KITTITAS COUNTY COMMUNITY DEVELOPMENT SERVICES

Subject: Shoreline Exemption Permit (SX-21-00001) - Request for Additional Information

SITE PLAN

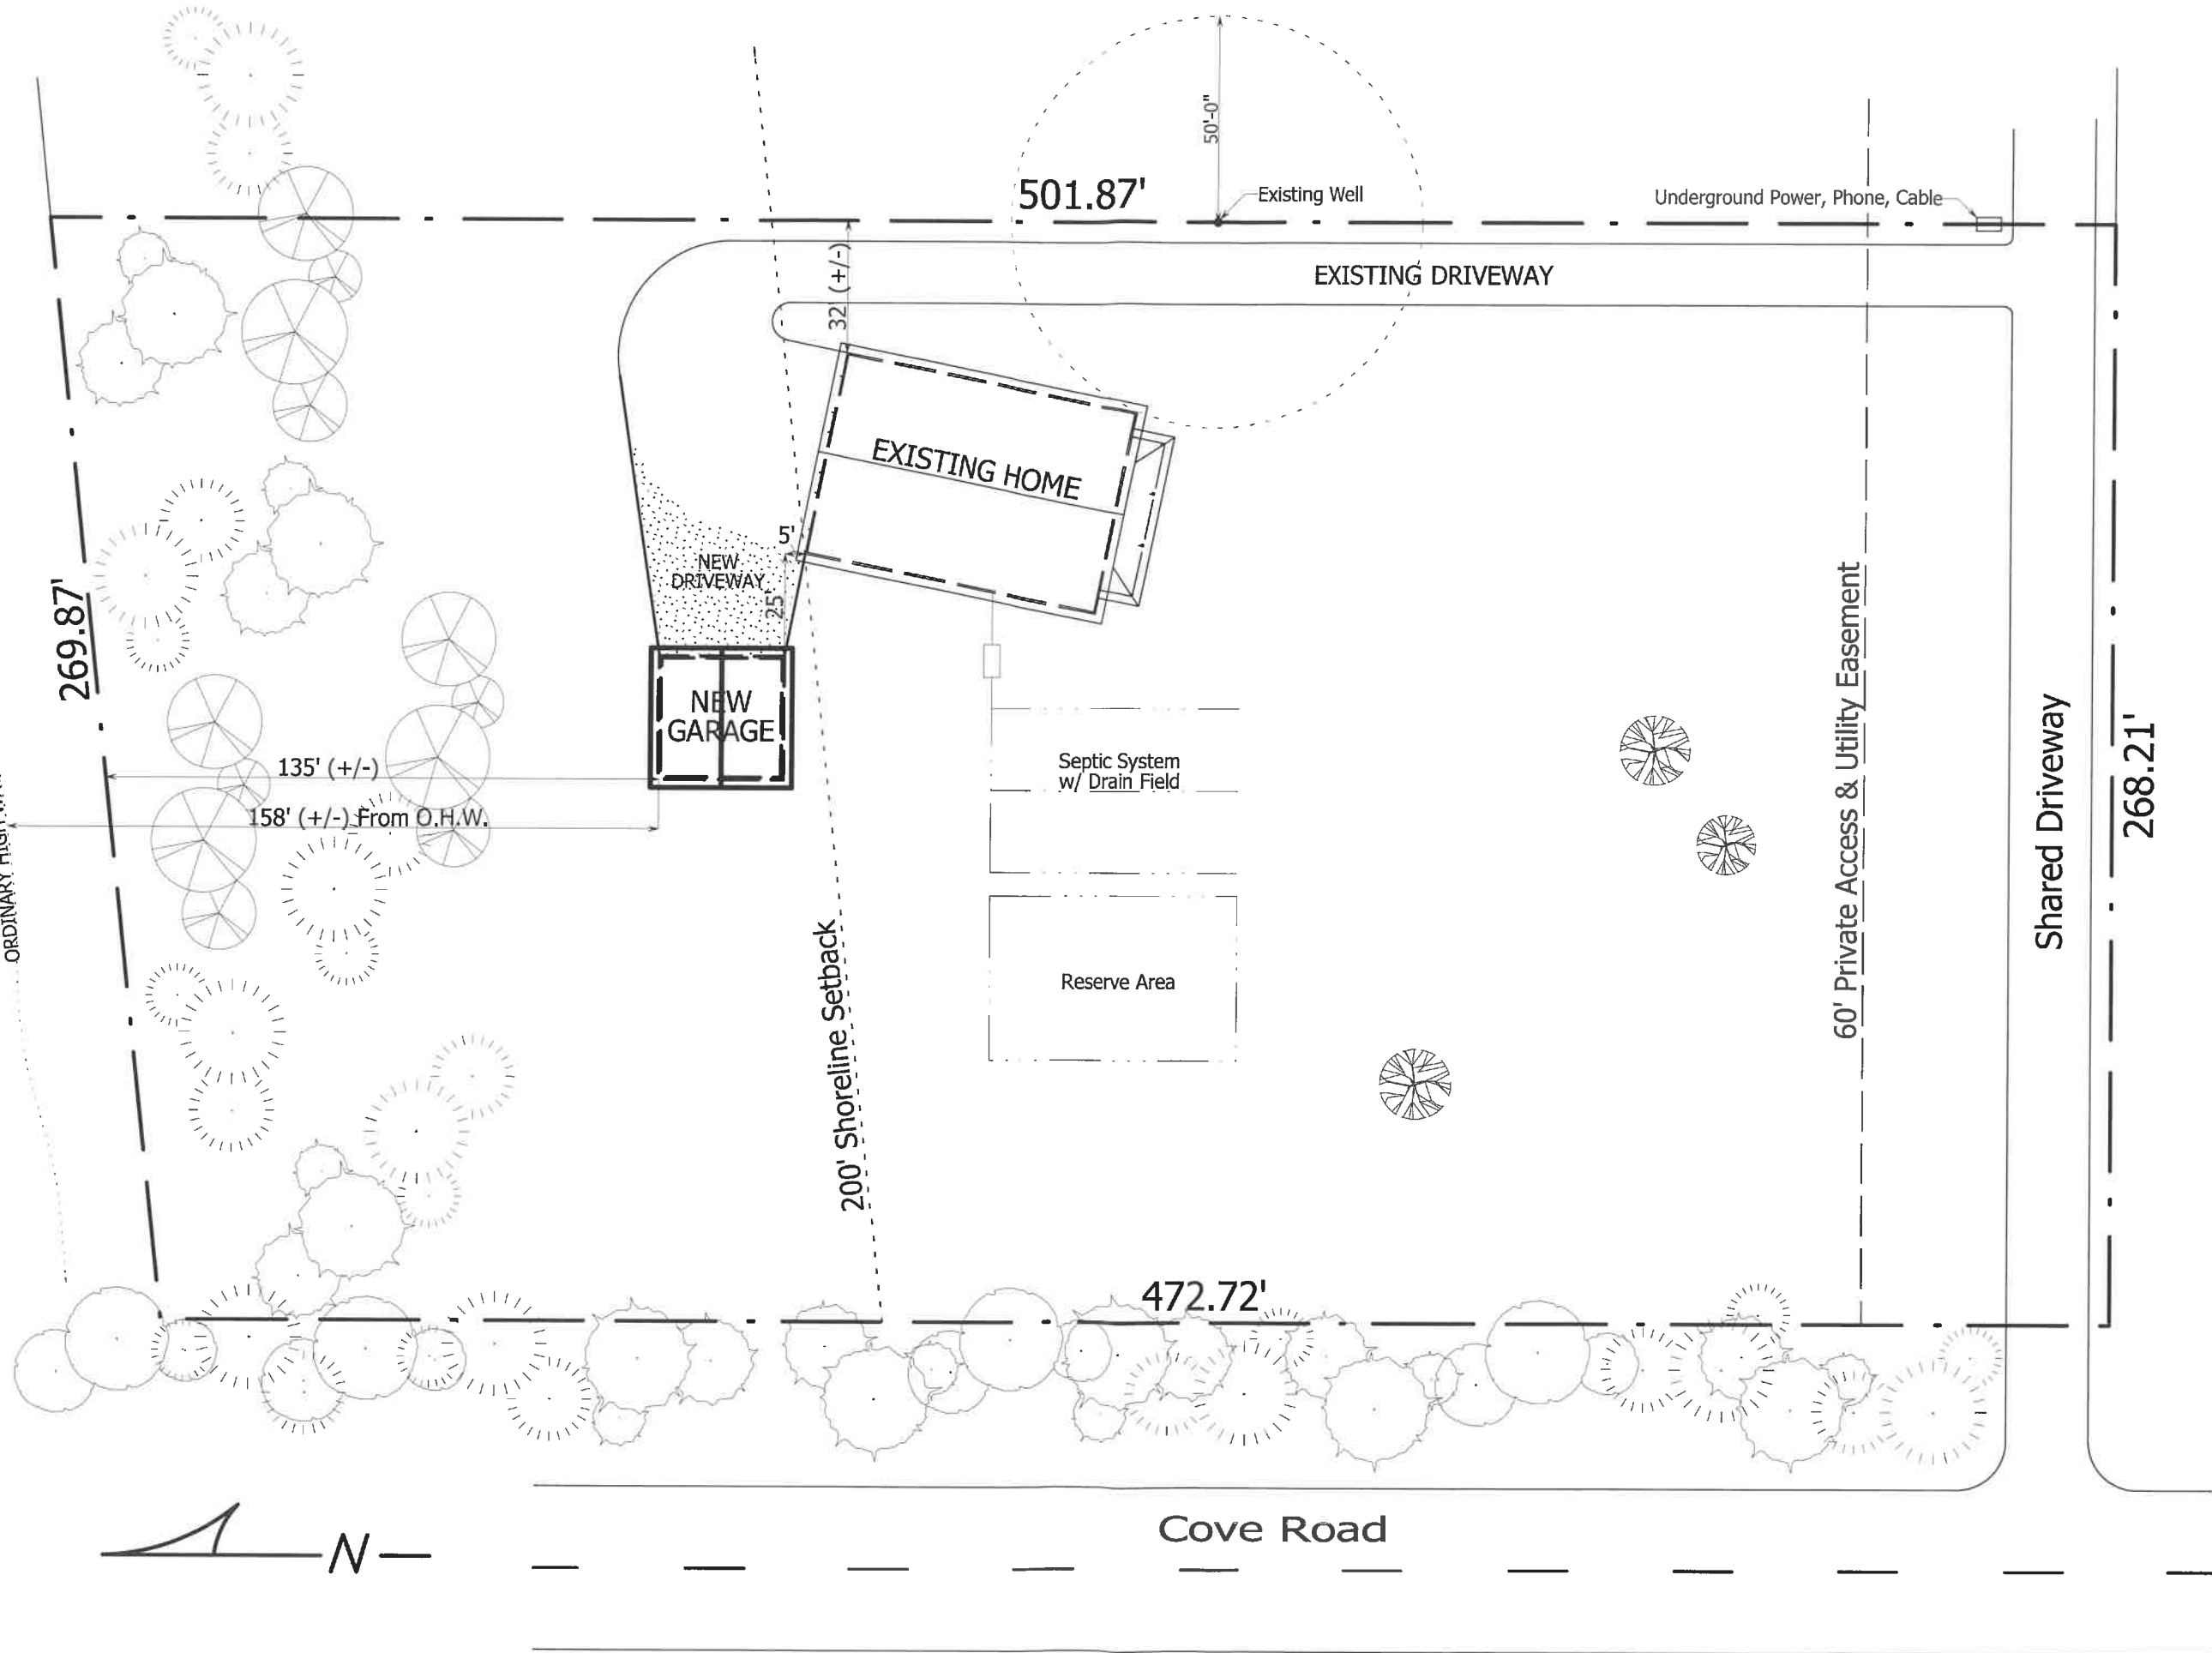
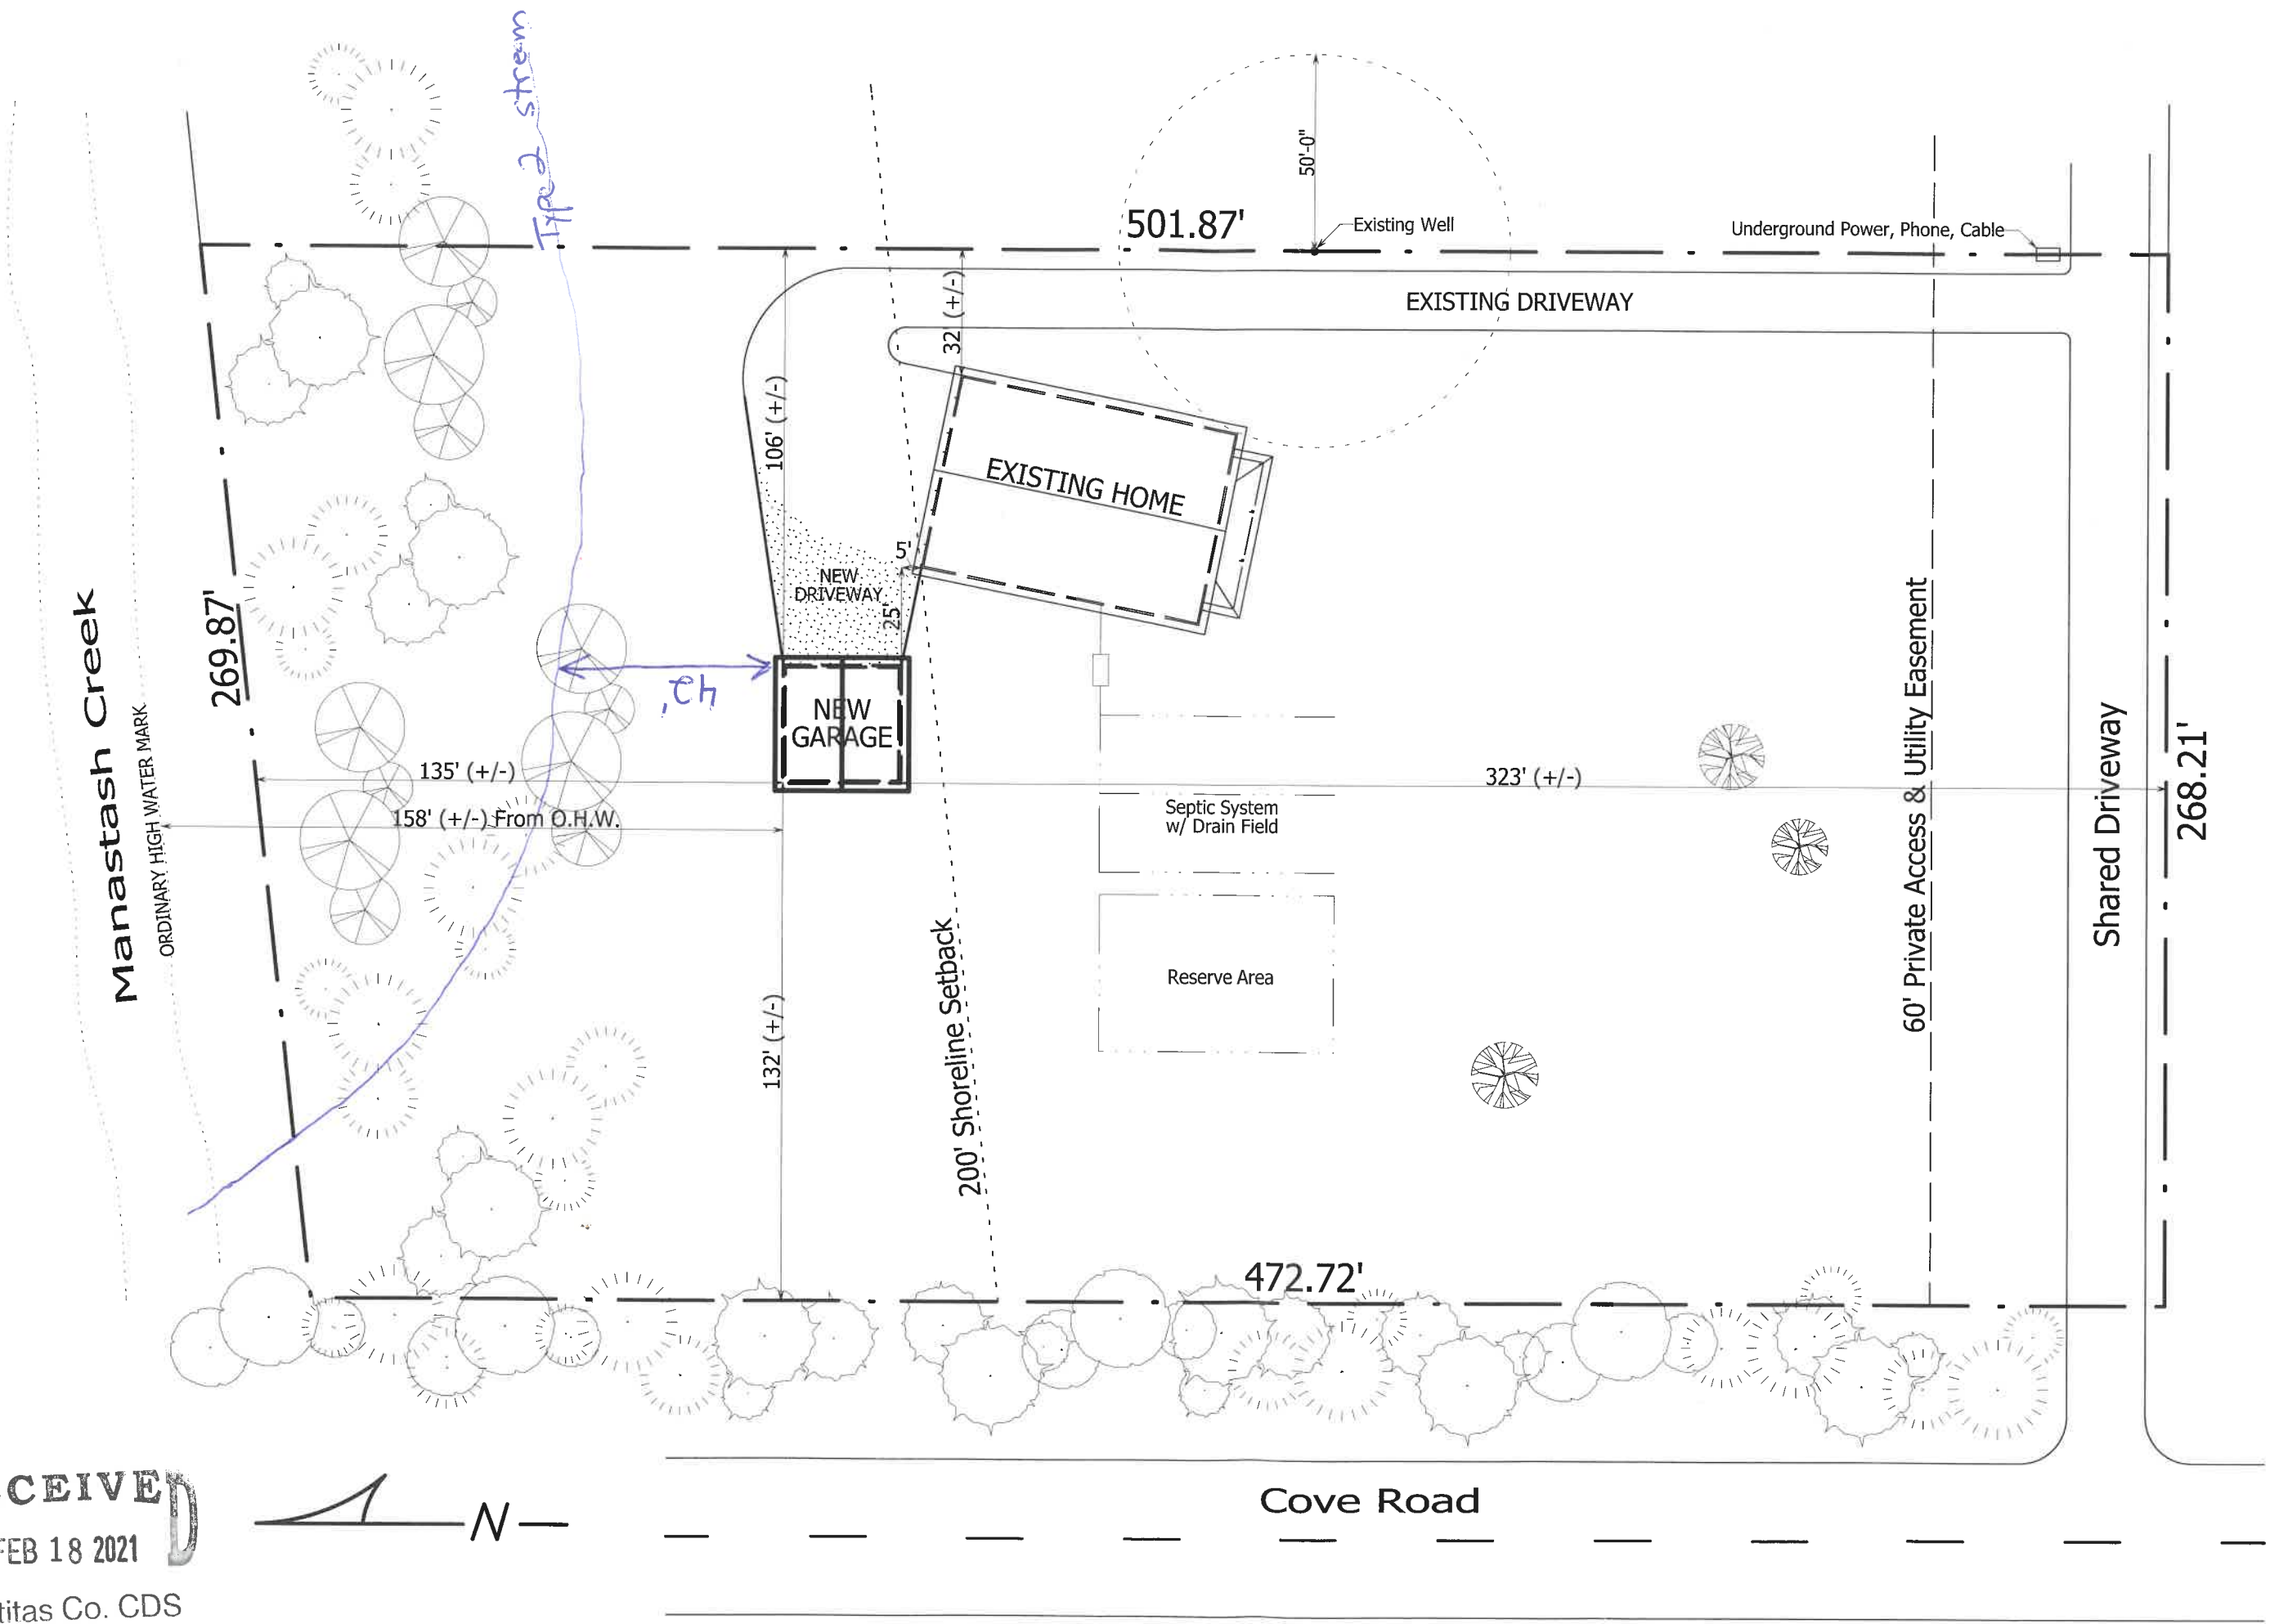
1. Updated site plan showing the following:
 - a. Our data shows a type 2 stream located on the property. Please update the site map to include the stream and the required 40' setback from the OHWM.
 - b. A profile view showing the horizontal distance from the OHWM to the edge of the new structure.

Please update your site plan accordingly.
